## Caitlin Cameron - Newbury Street project

**From:** Christian MilNeil <c.neal.milneil@gmail.com>  
**To:** Caitlin Cameron <CCameron@portlandmaine.gov>  
**Date:** 2/12/2016 3:18 PM  
**Subject:** Newbury Street project

Thanks for letting me look over the plans for the Newbury Street project.

1 | FRANKLIN STREET ELEVATION
 1/8" = 1'-0"
 0 4'-0" 8'-0" 16'-0" 32'-0"

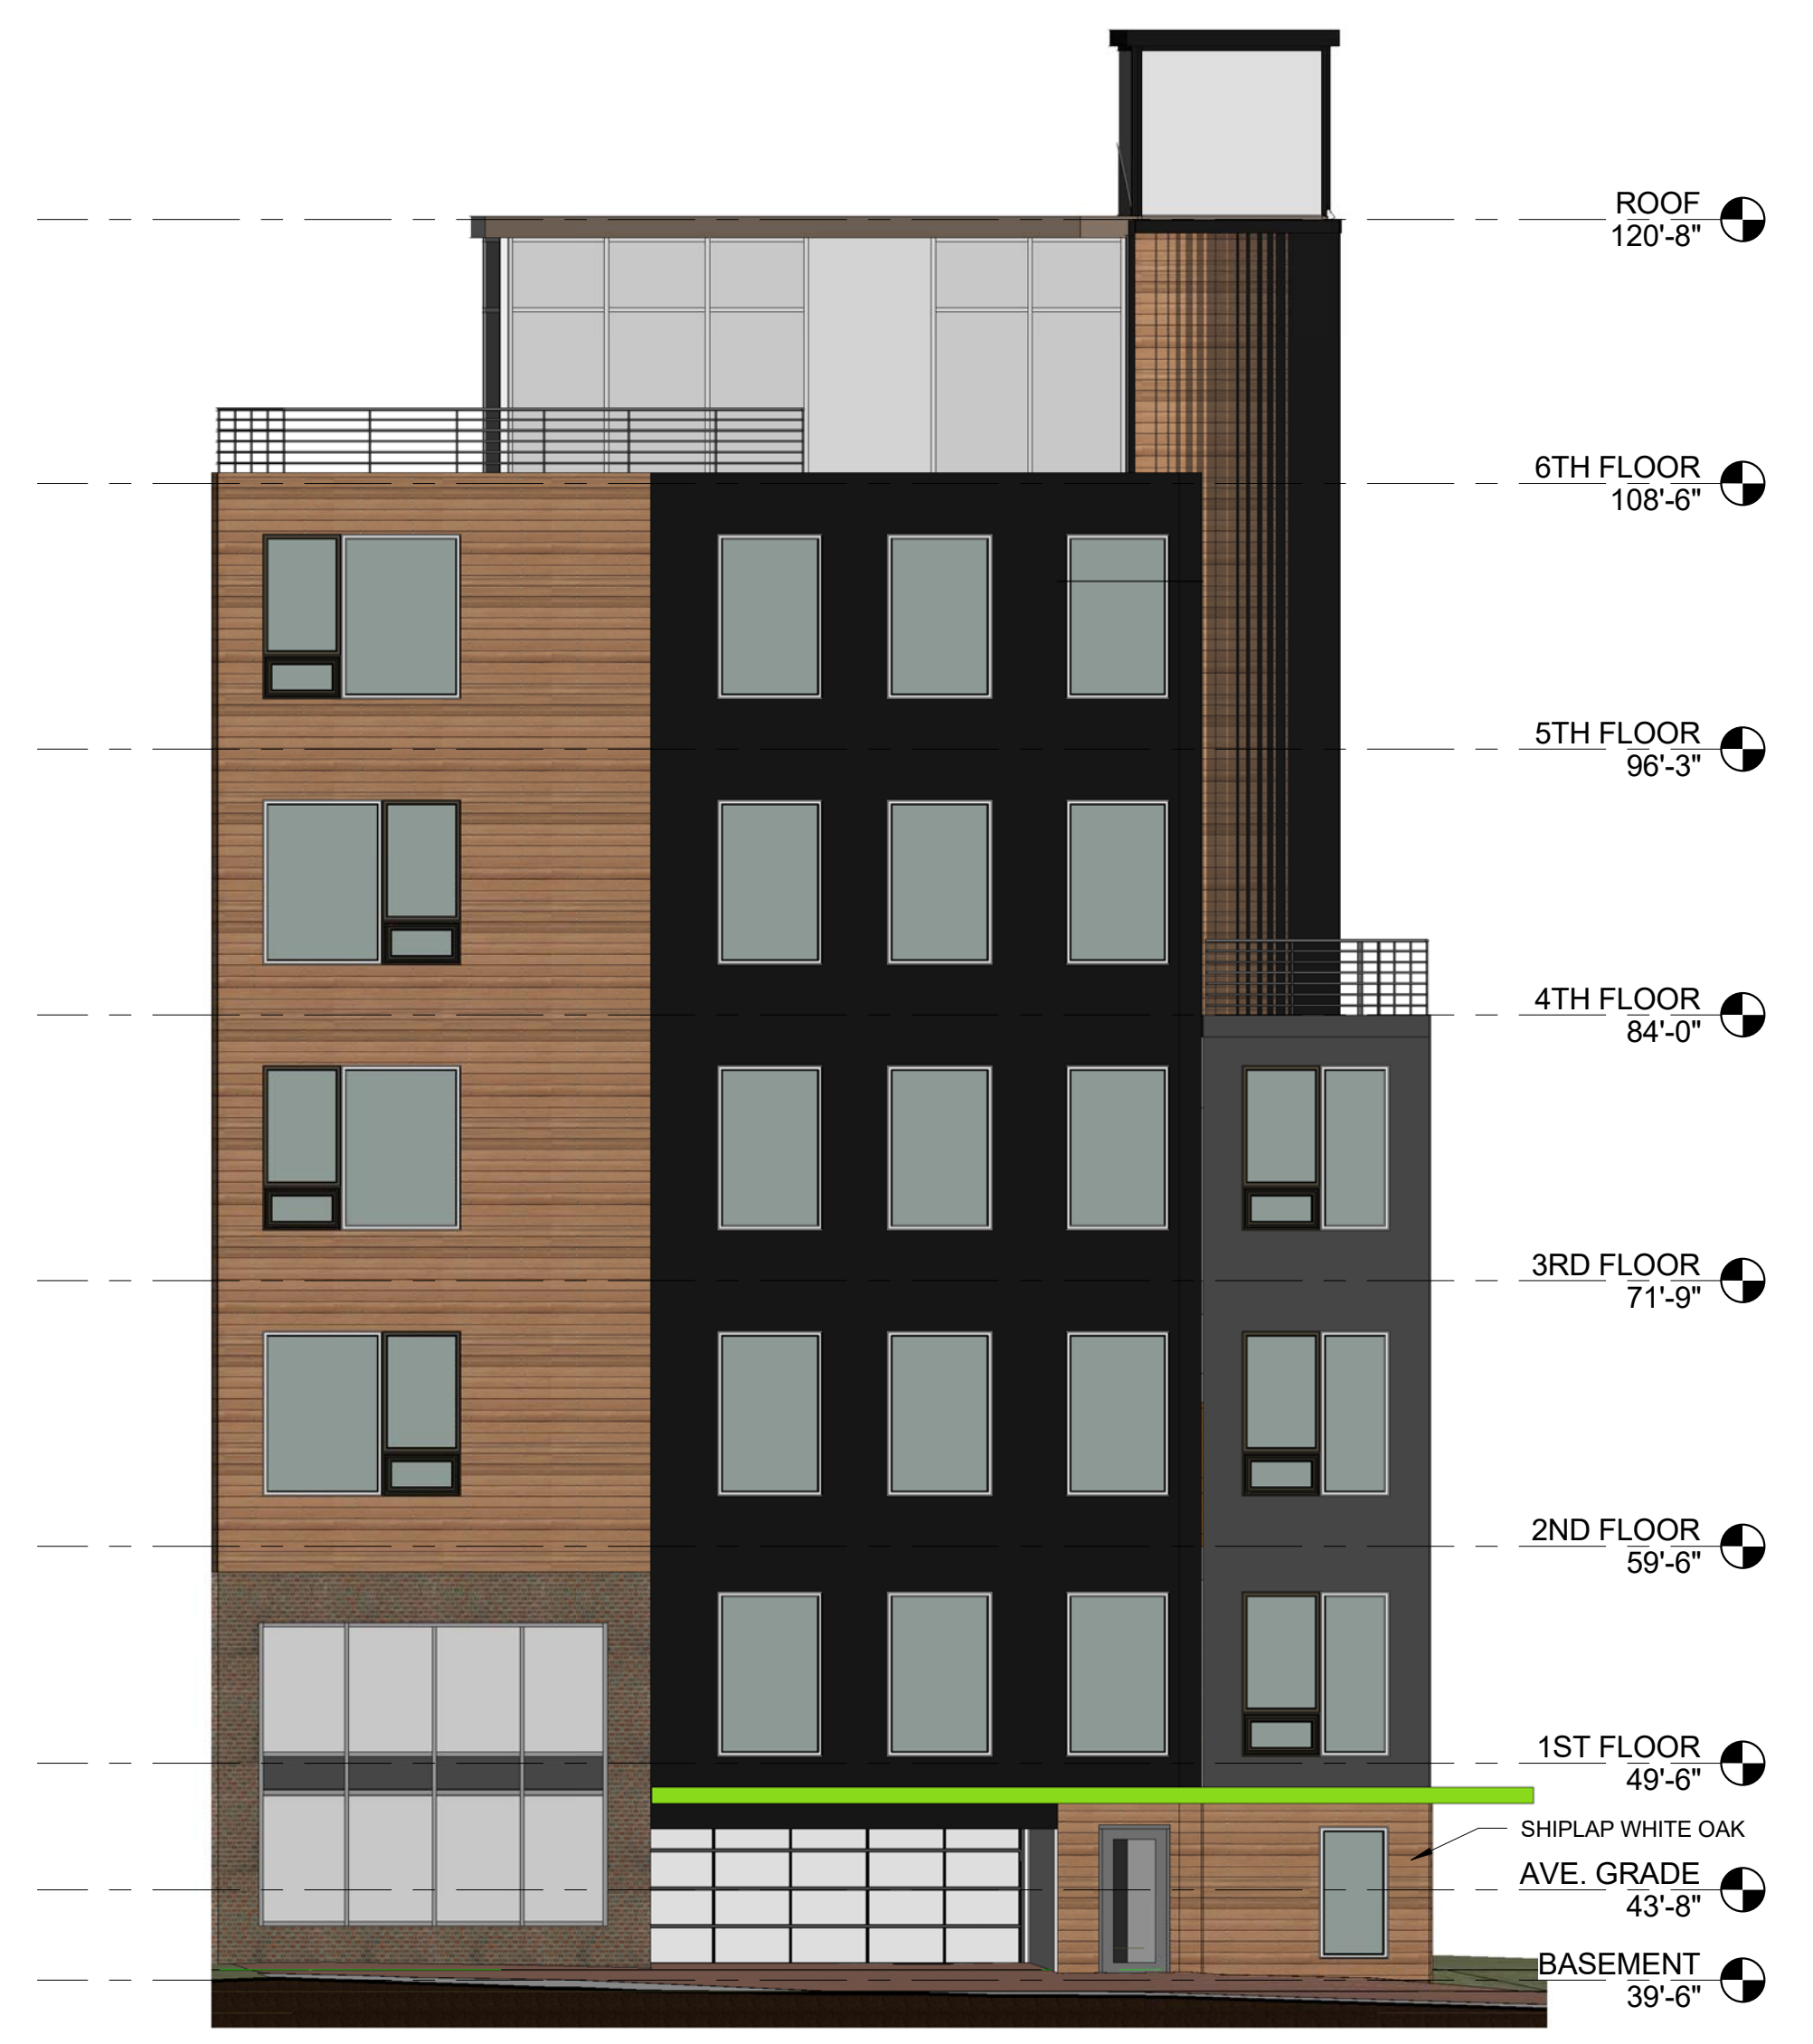
Still, as you may have guessed, the blank parking garage wall facing the ground level of Franklin Street grates on me. Even if it's allowed under the new form based code, that doesn't mean it doesn't violate the spirit of the city's design principles. Franklin Street already suffers from parking garage facades on the office buildings south of Middle Street, and it's a precedent we shouldn't be perpetuating.

With that in mind, then, I'd like to request that the city treat the Franklin "facade" of 167 Newbury as only a temporary corner lot, with the expectation that there will be a future building going up along the new Franklin Street sidewalk when the excess right-of-way becomes available for redevelopment.

In other words, the developers of 167 Newbury should be allowed the zoning benefits of being on a corner lot for this project, in reflection of existing conditions. However, in recognition of the Franklin Street plan, this building's SW facade ought to be built as a party wall that can accommodate another building on the new corner lot when the Franklin Street reconstruction is complete.
